Autumn Acres
Master Traffic Impact Analysis
(LSC #S224050)
PCD File No.: EA-226
December 23, 2022

Replace with SKP231

Autumn Acres

Master Traffic Impact Analysis

Figure 3
**School
 Pedestrian Plan**
 Autumn Acres (LSC #S224050)

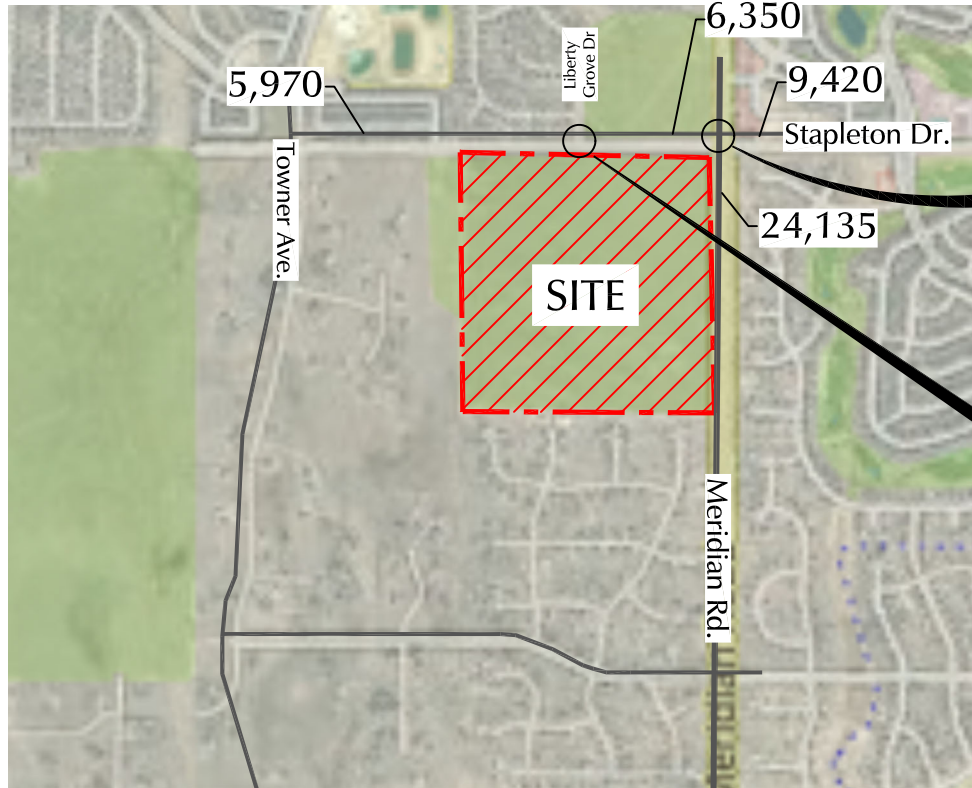
The west side of Towner avenue from Jagger Way to Londonderry has a sidewalk. Revise accordingly.

ZONING MAP

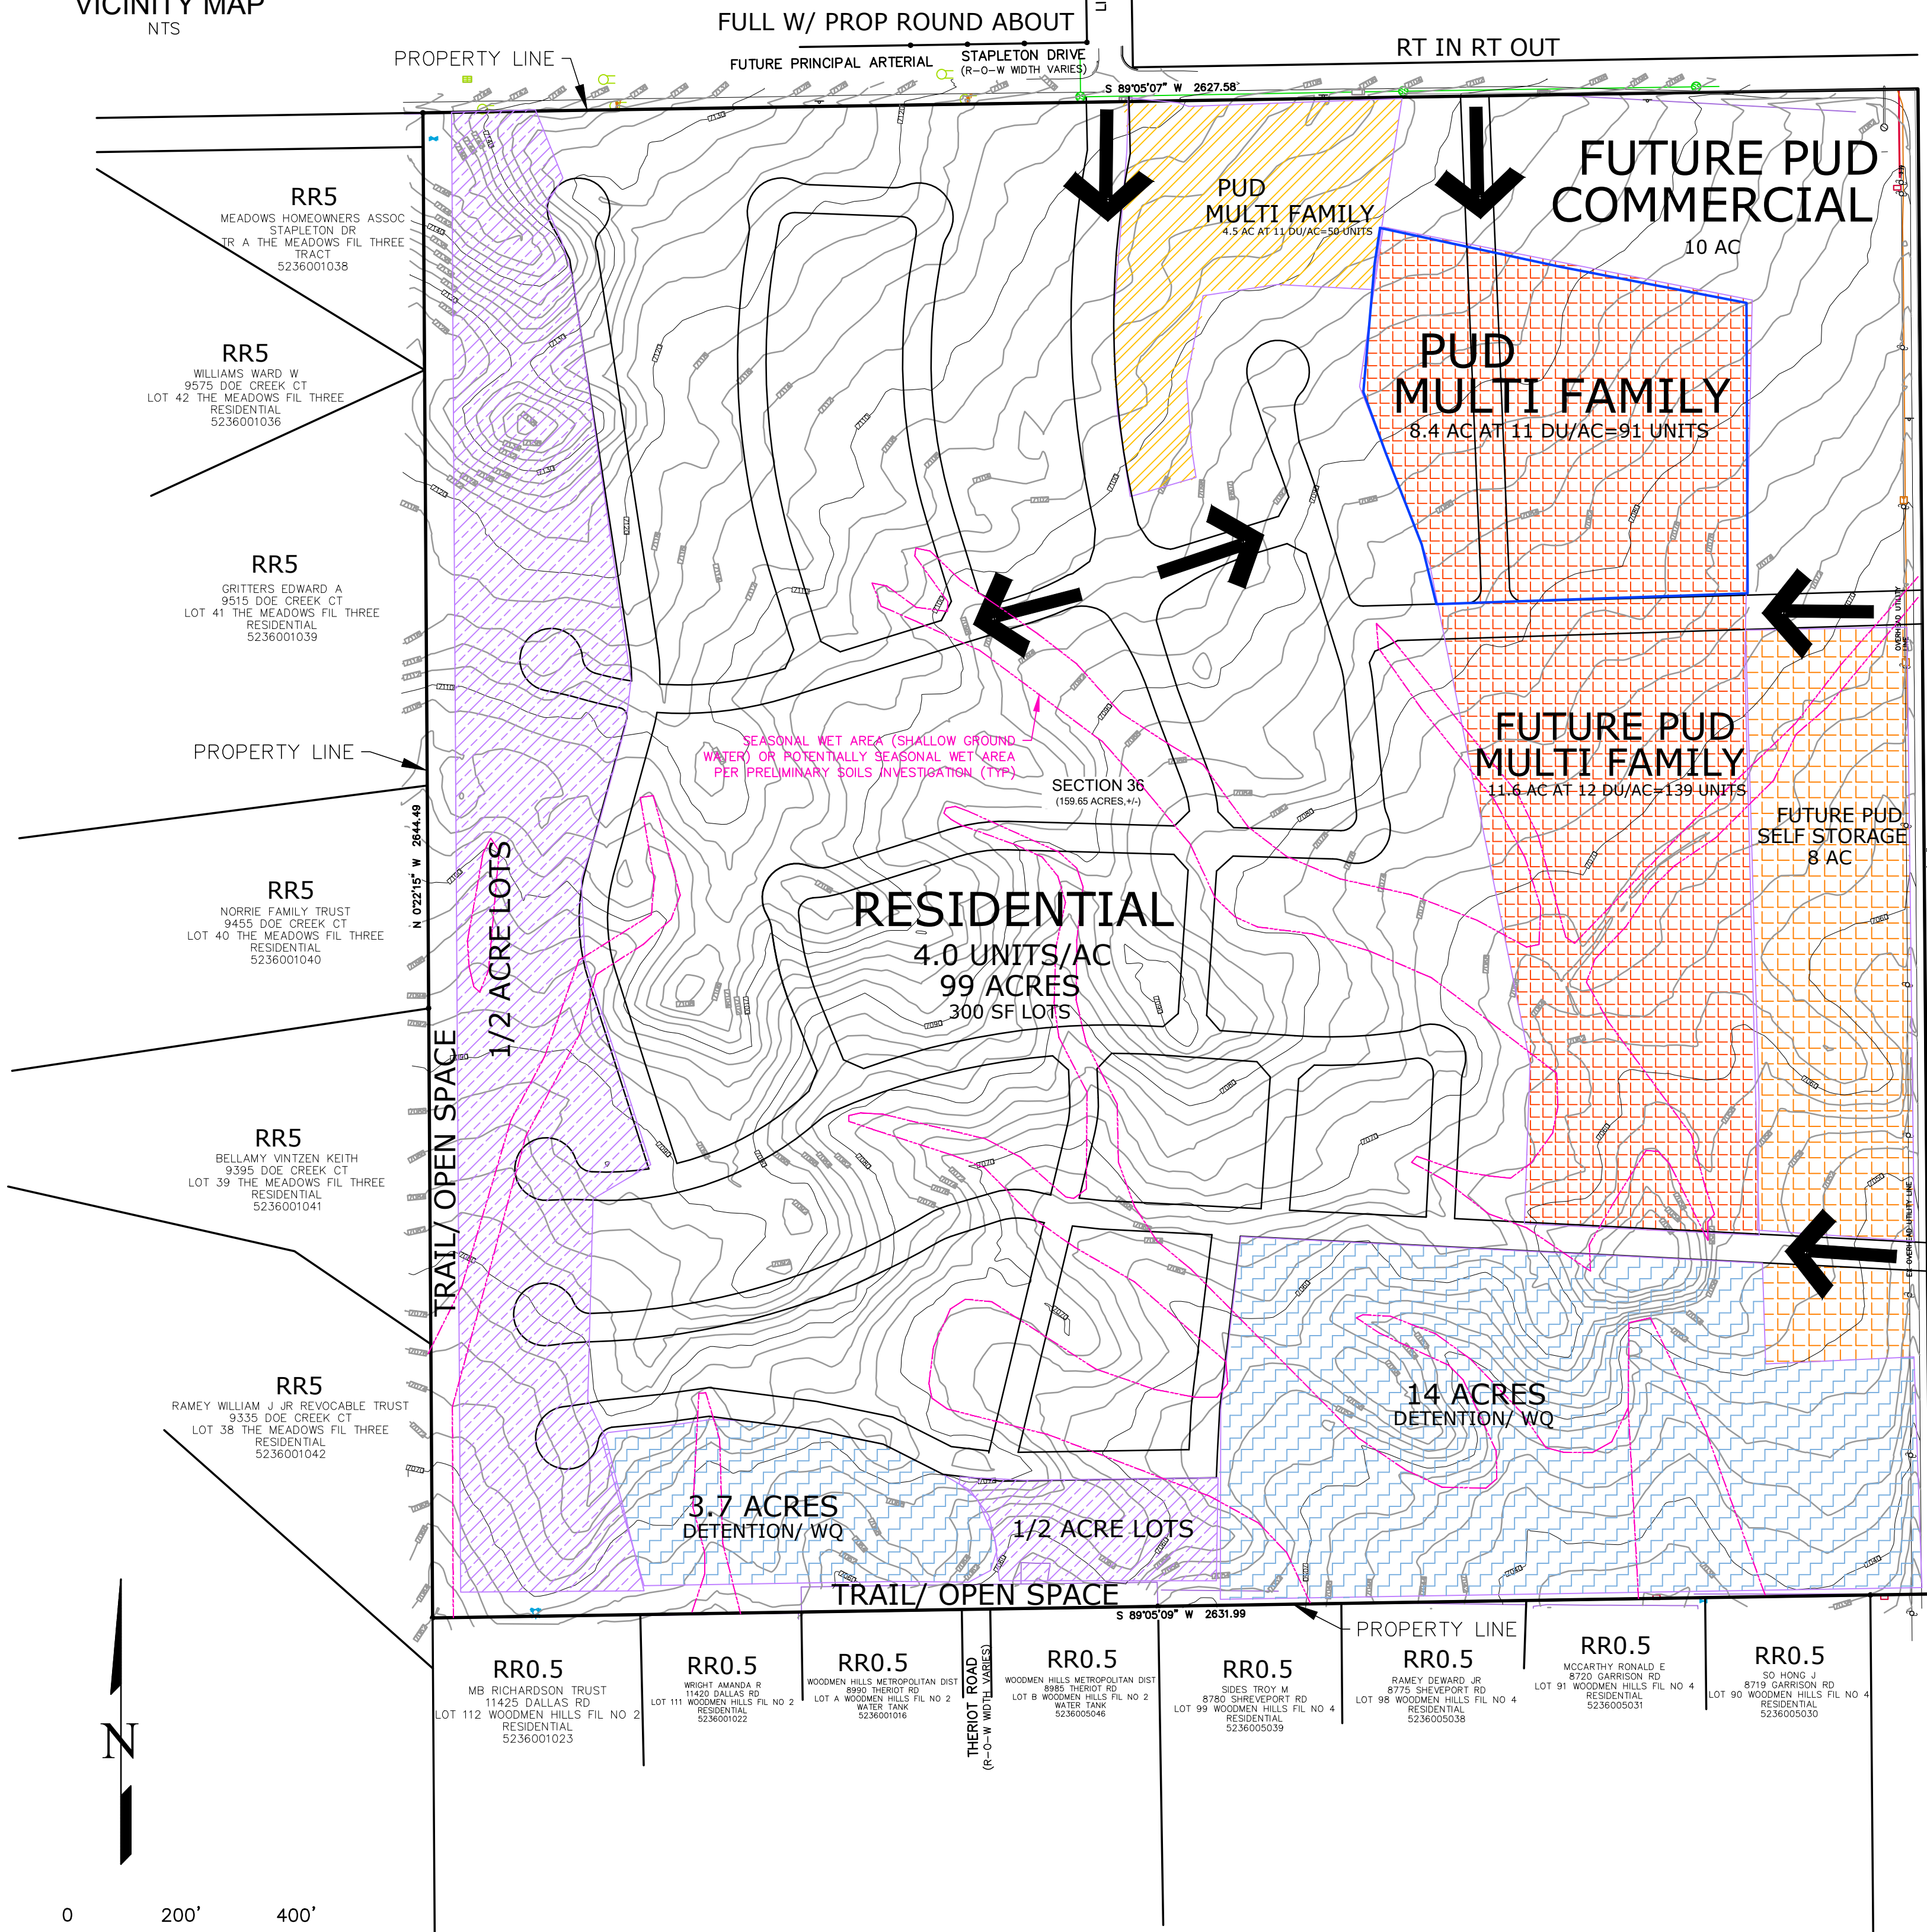
Please see comments on the sketch plan document regarding the proposed access points and revise the analysis accordingly.
Also, refer to comments provided by the traffic consultant FHU that are posted on EDARP.

Remove from analysis.

Update analysis. The northern access is not likely to be approved.
